PLANNING APPLICATIONS AND S106 OBLIGATIONS

Reference A. Planning Application 19/02550/F
B. Planning Obligations 21/03164/OBL

THIS DRAWING IS THE COPYRIGHT OF SWAN GOLF DESIGNS LTD AND MUST NOT BE REPRODUCED IN FULL OR IN PART WITHOUT THE WRITTEN PERMISSION OF WILLIAM SWAN ON BEHALF OF THE COPYRIGHT HOLDER.

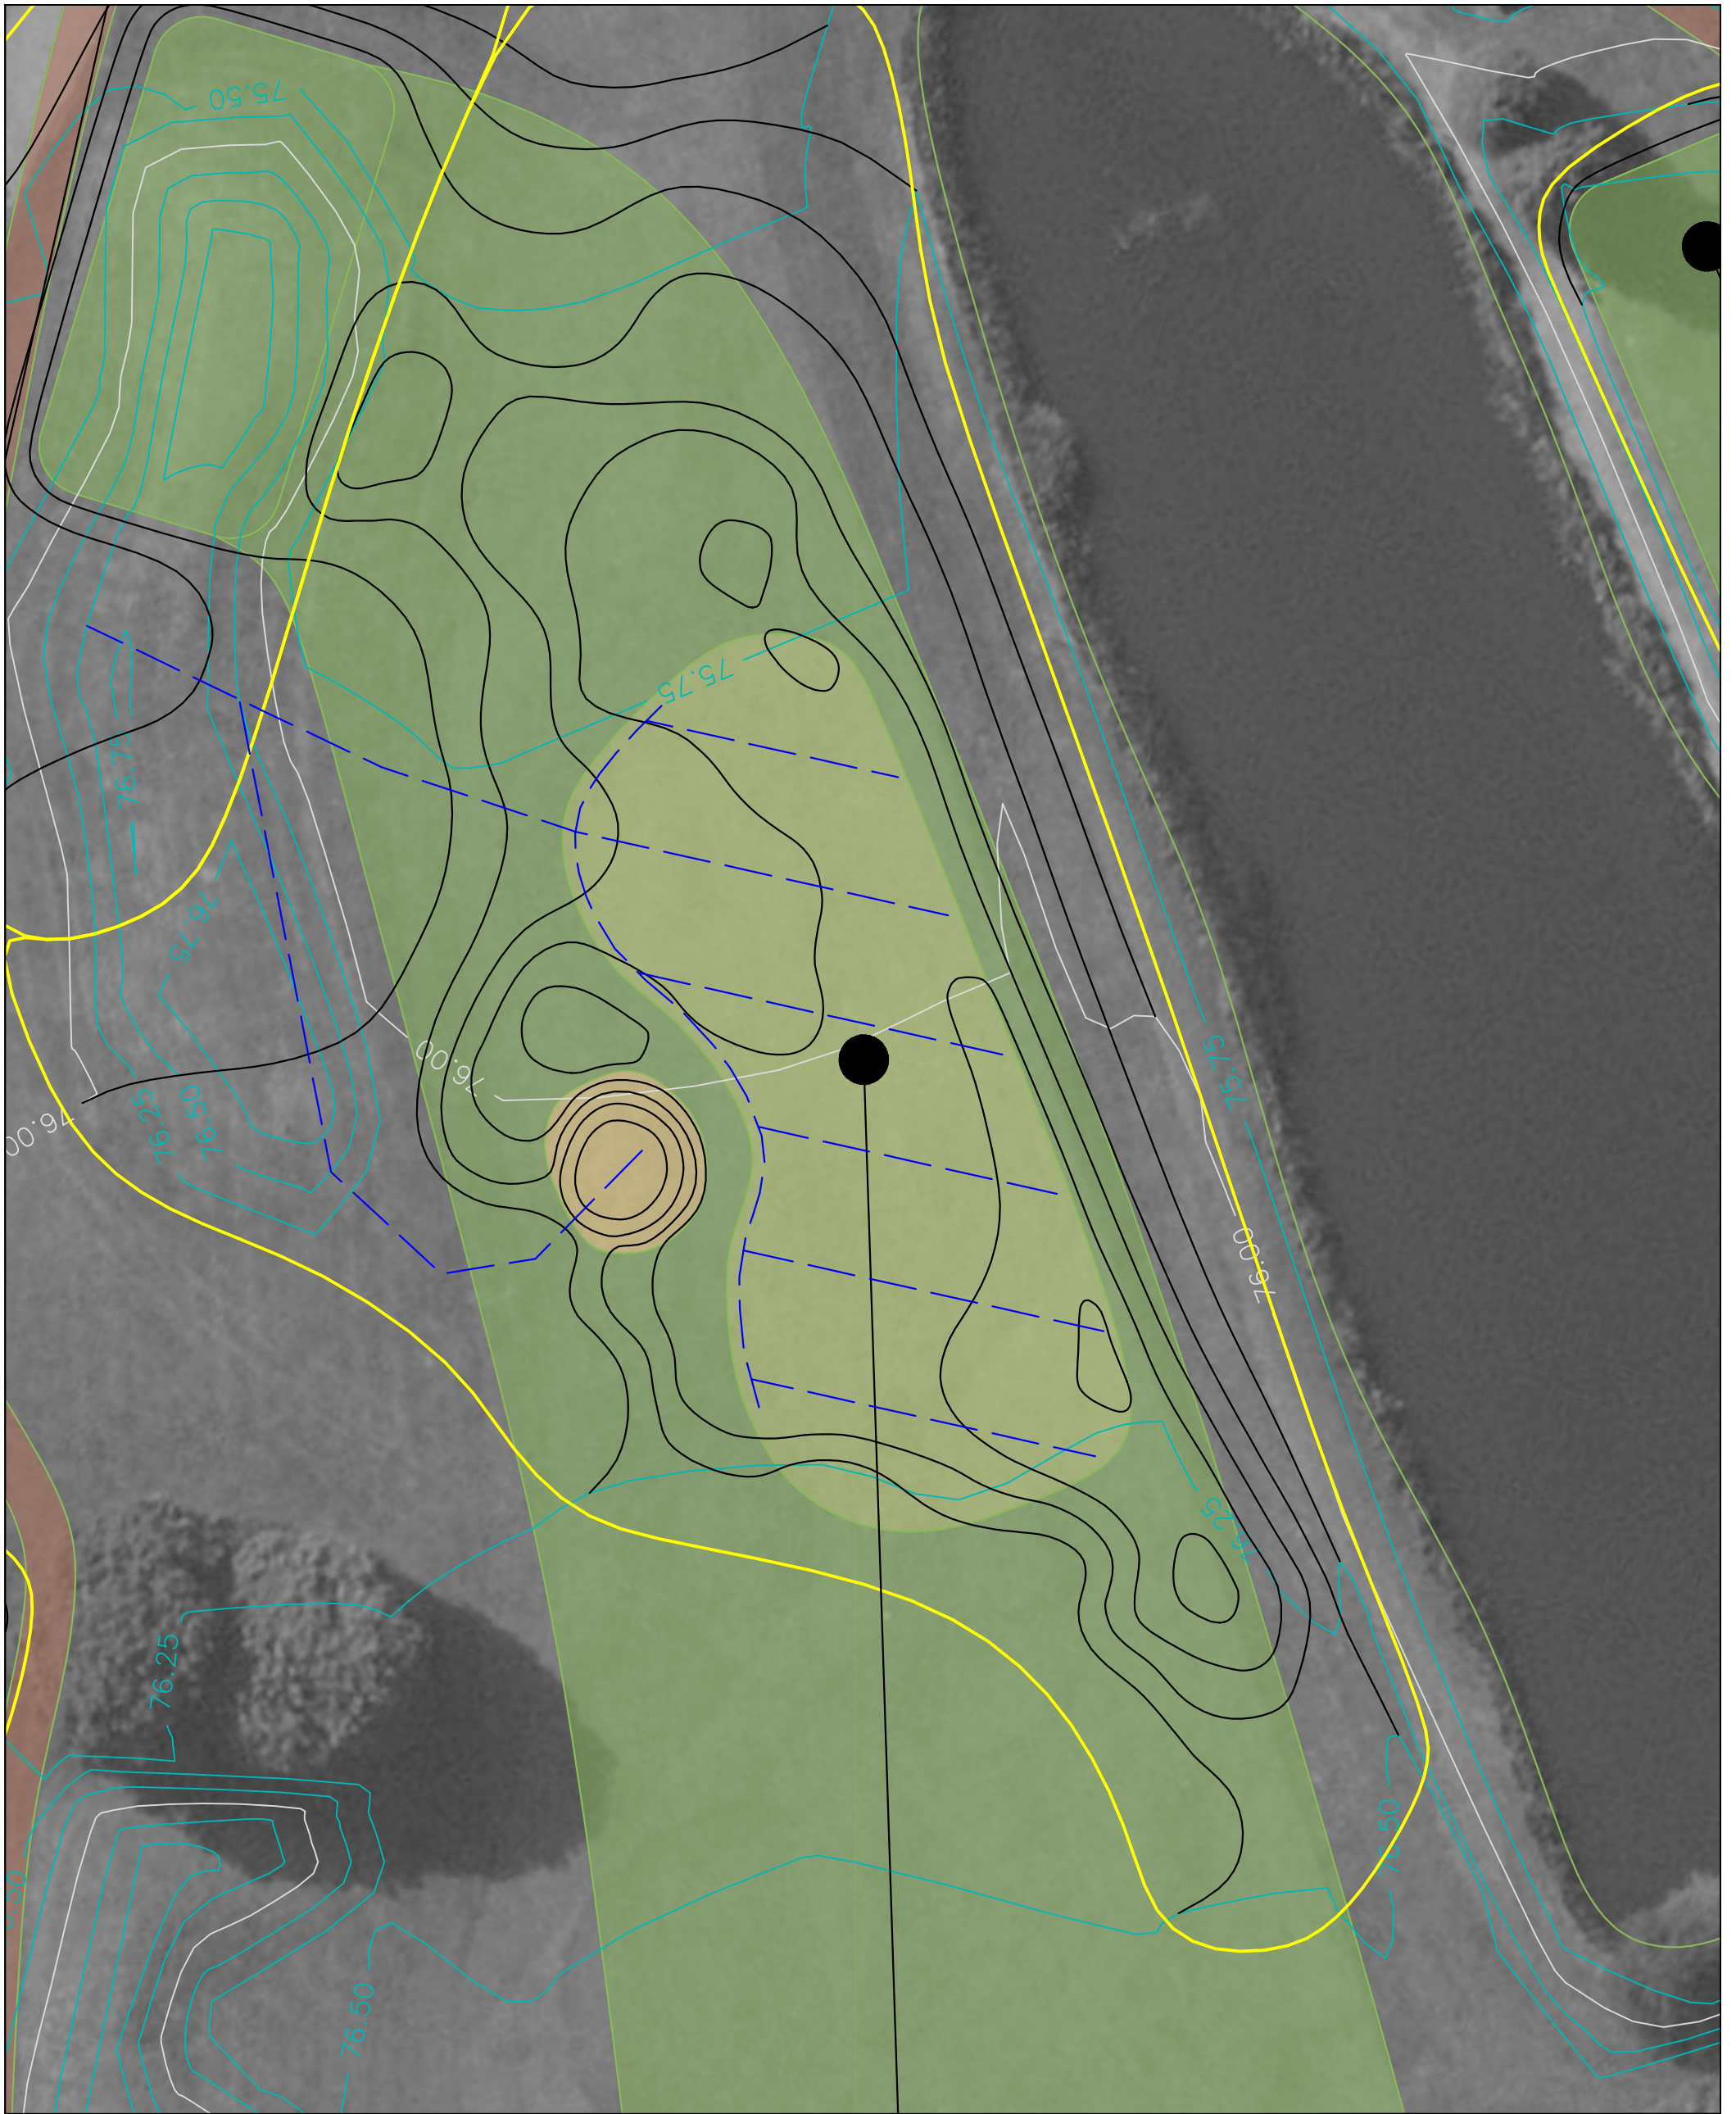
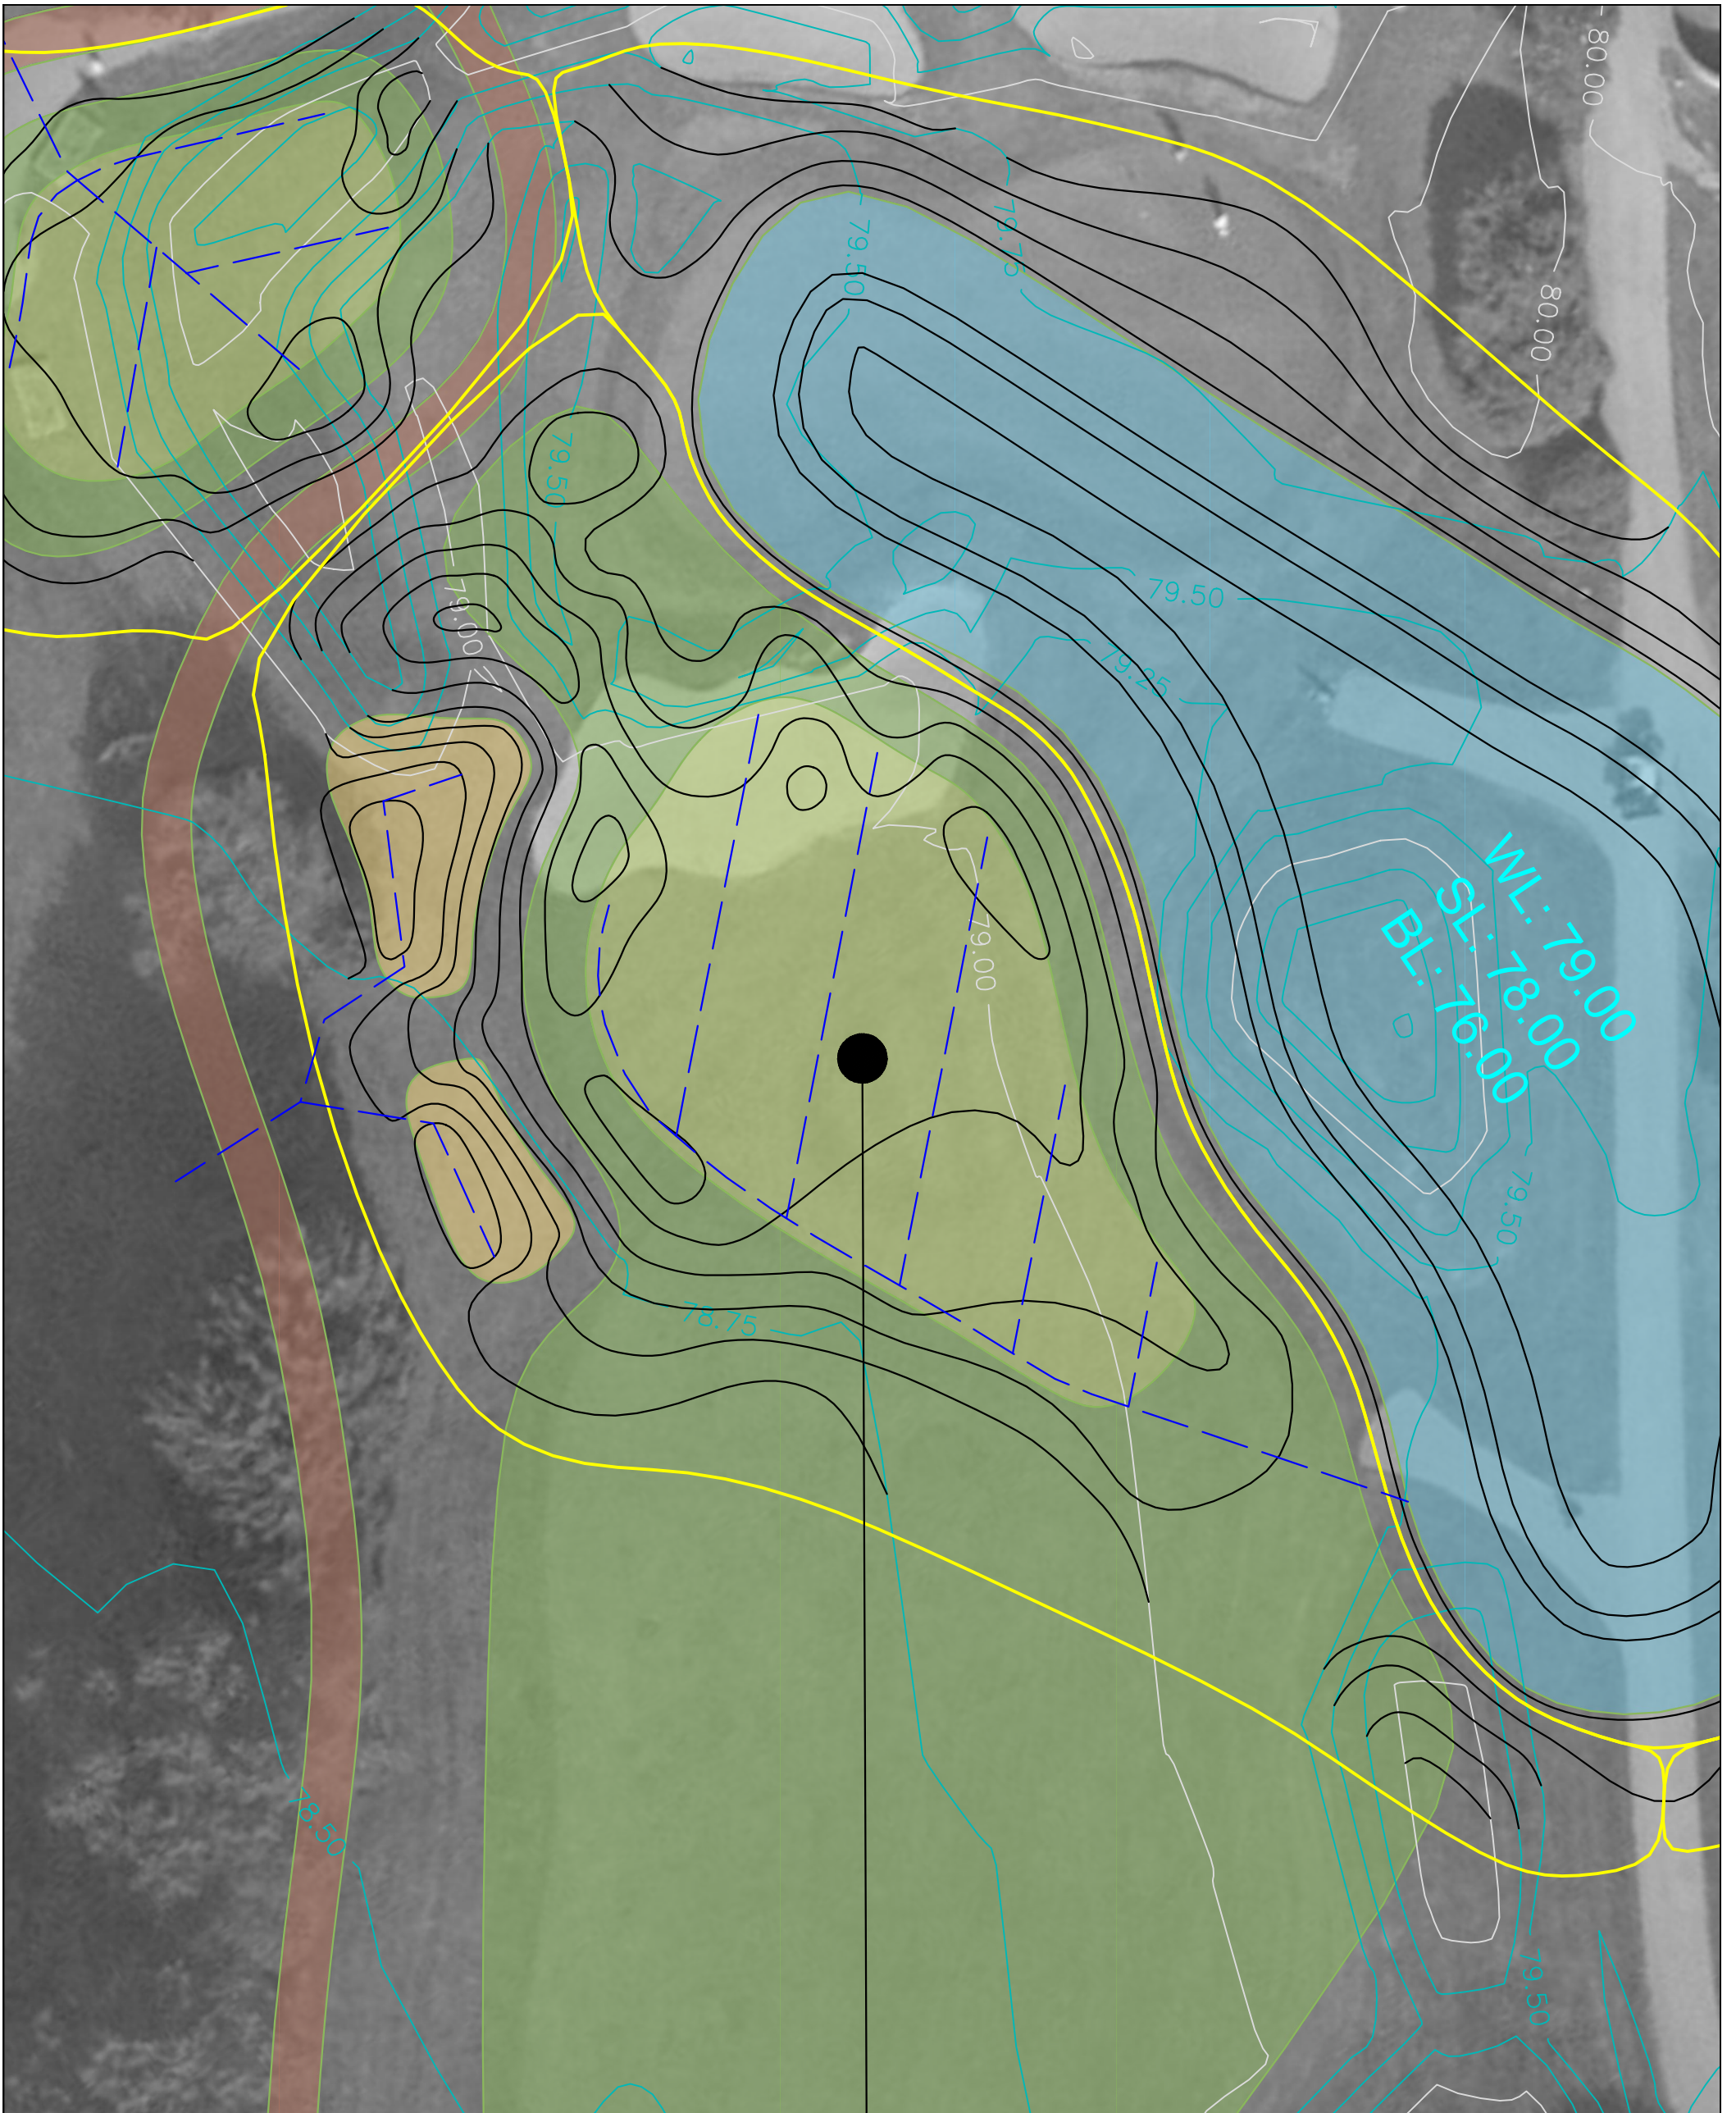
1. In particular they fail to properly address the matters of Health and Safety regarding the crossover points of golfers on the proposed new golf course layout. They do not provide any plan for the holes 10 to 18 where conflict when playing different circuits occurs. The only course plan provided is for holes 1 to 6. It seems their plan has not been submitted to Golf England for over-site and approval, yet the designer say it's an improved golfing facility. This is insufficient information for discharge to proceed.

DETAILED DESIGN
ACADEMY GREENS

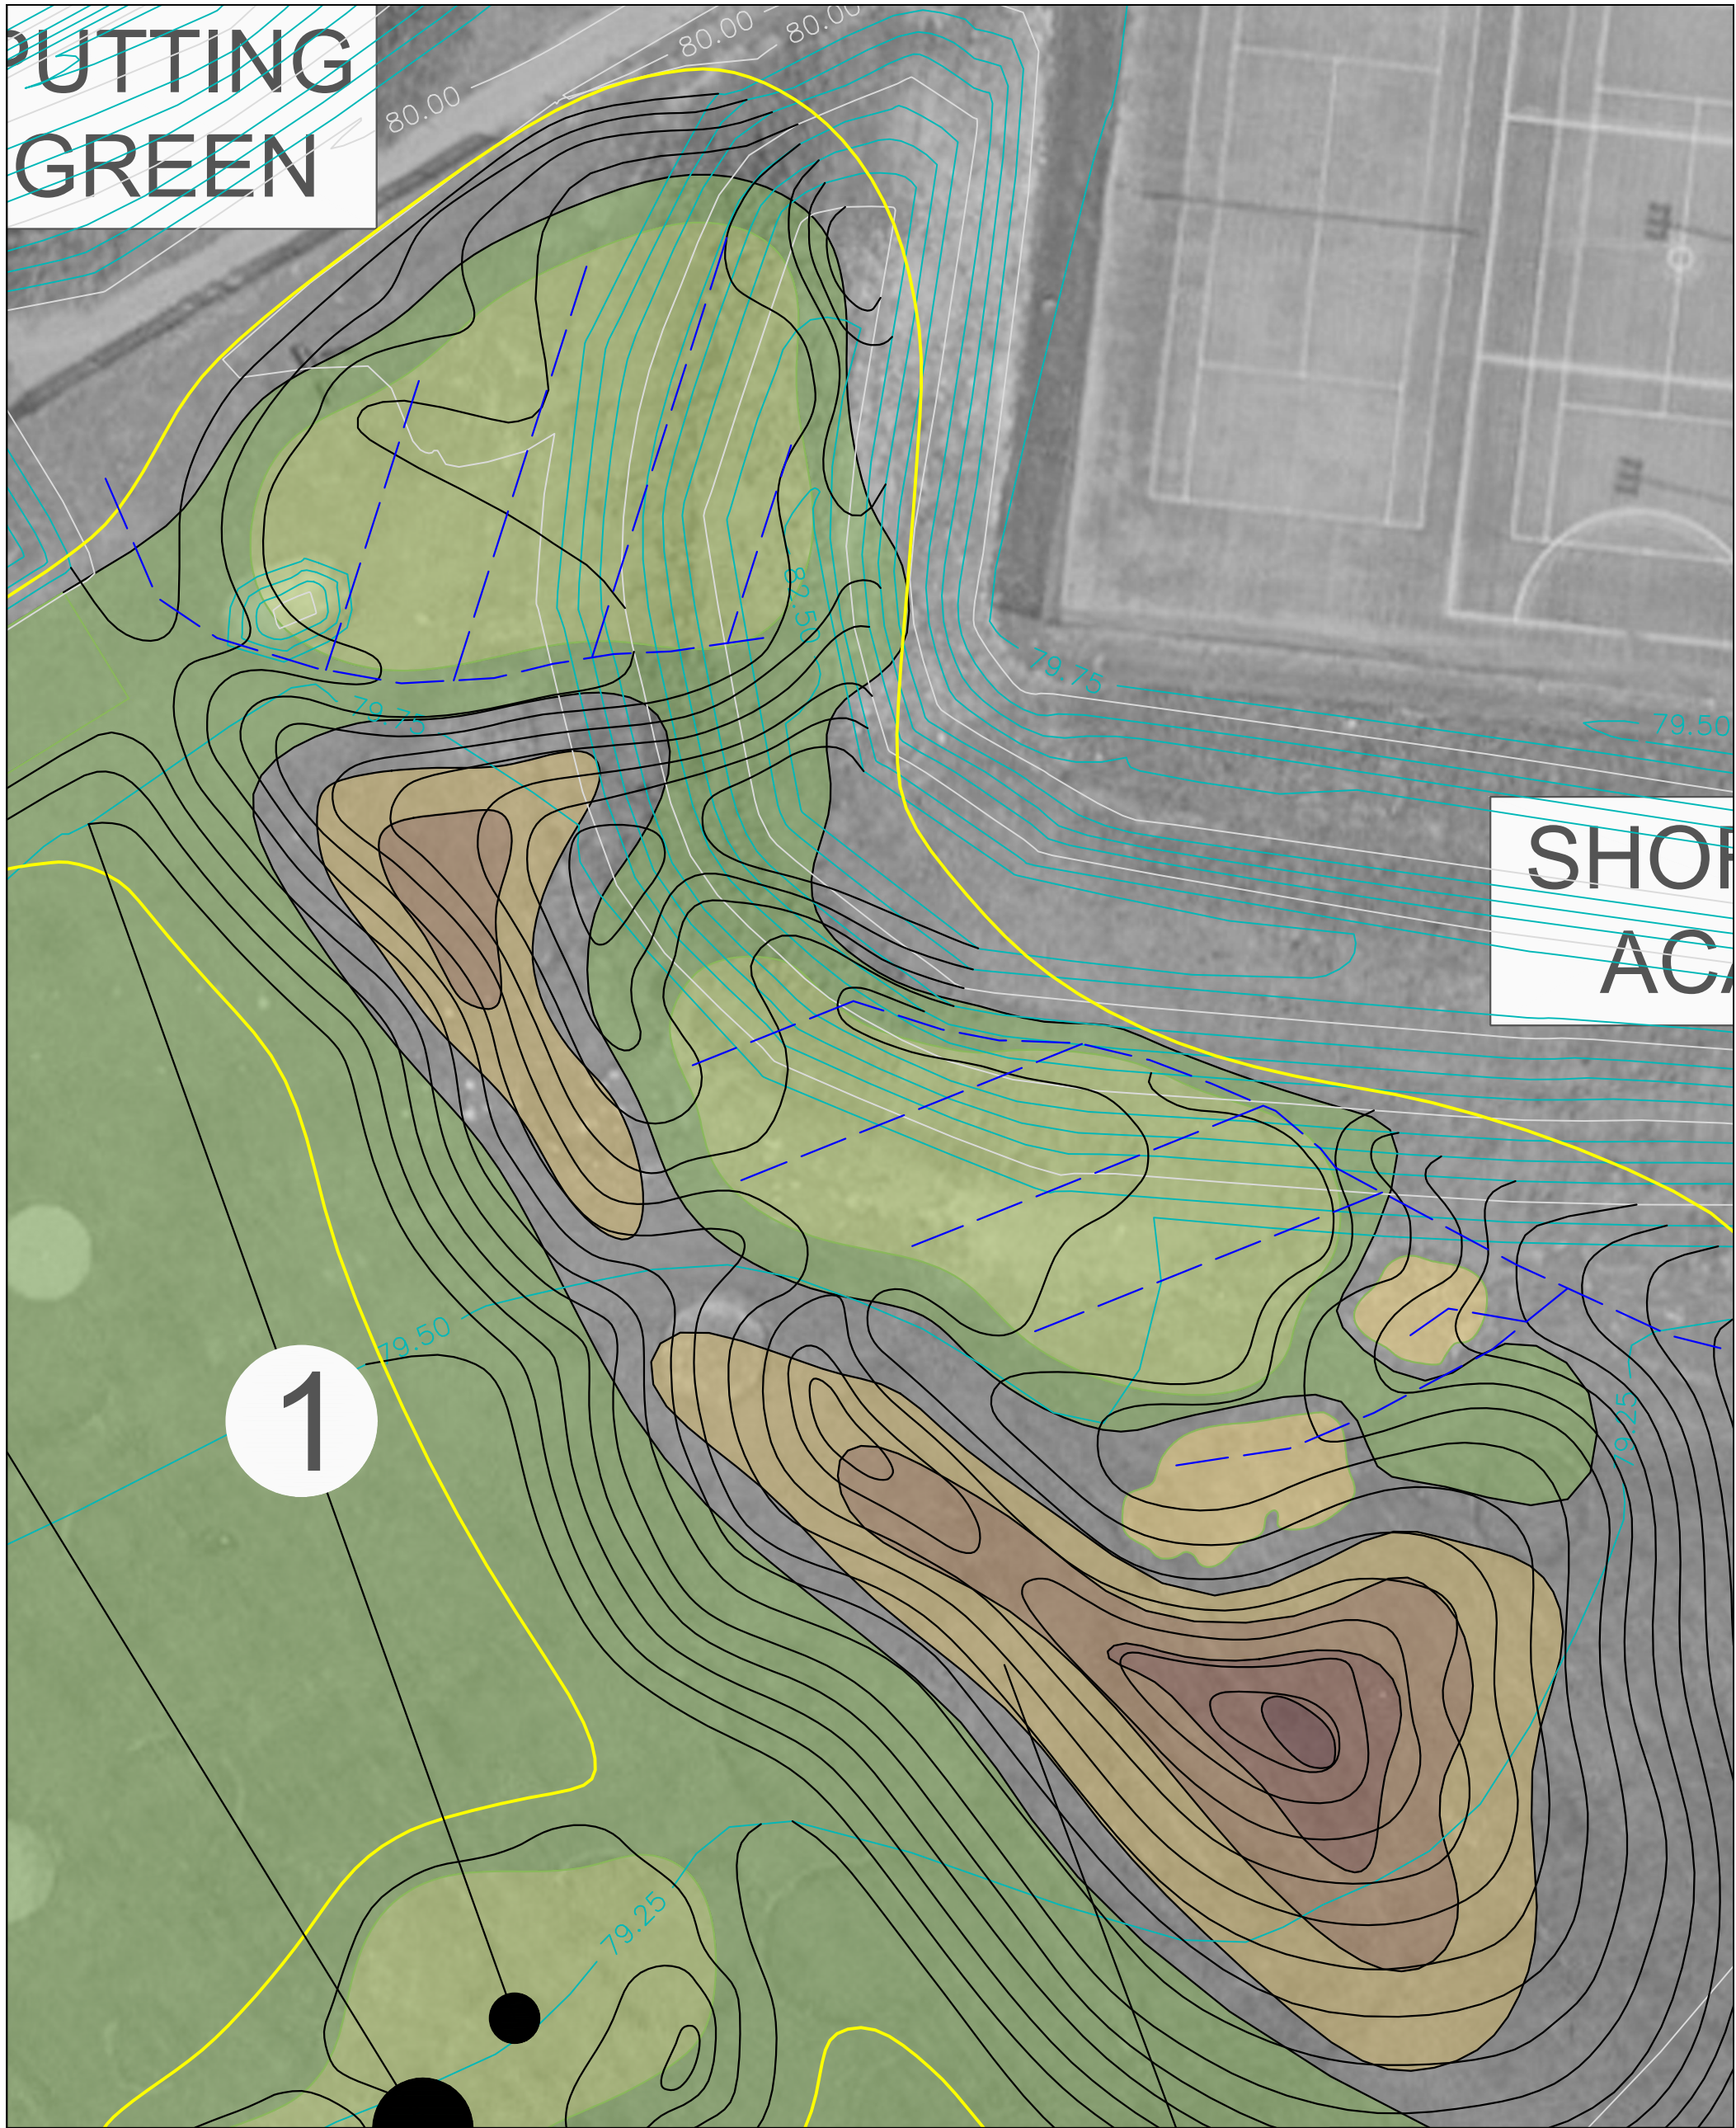
5. The practice area of 12 separate bays was to have one bay with a Laser Ball Tracking device (Track-Man or similar) but there is nothing on the discharge plans to confirm this obligation will be met.
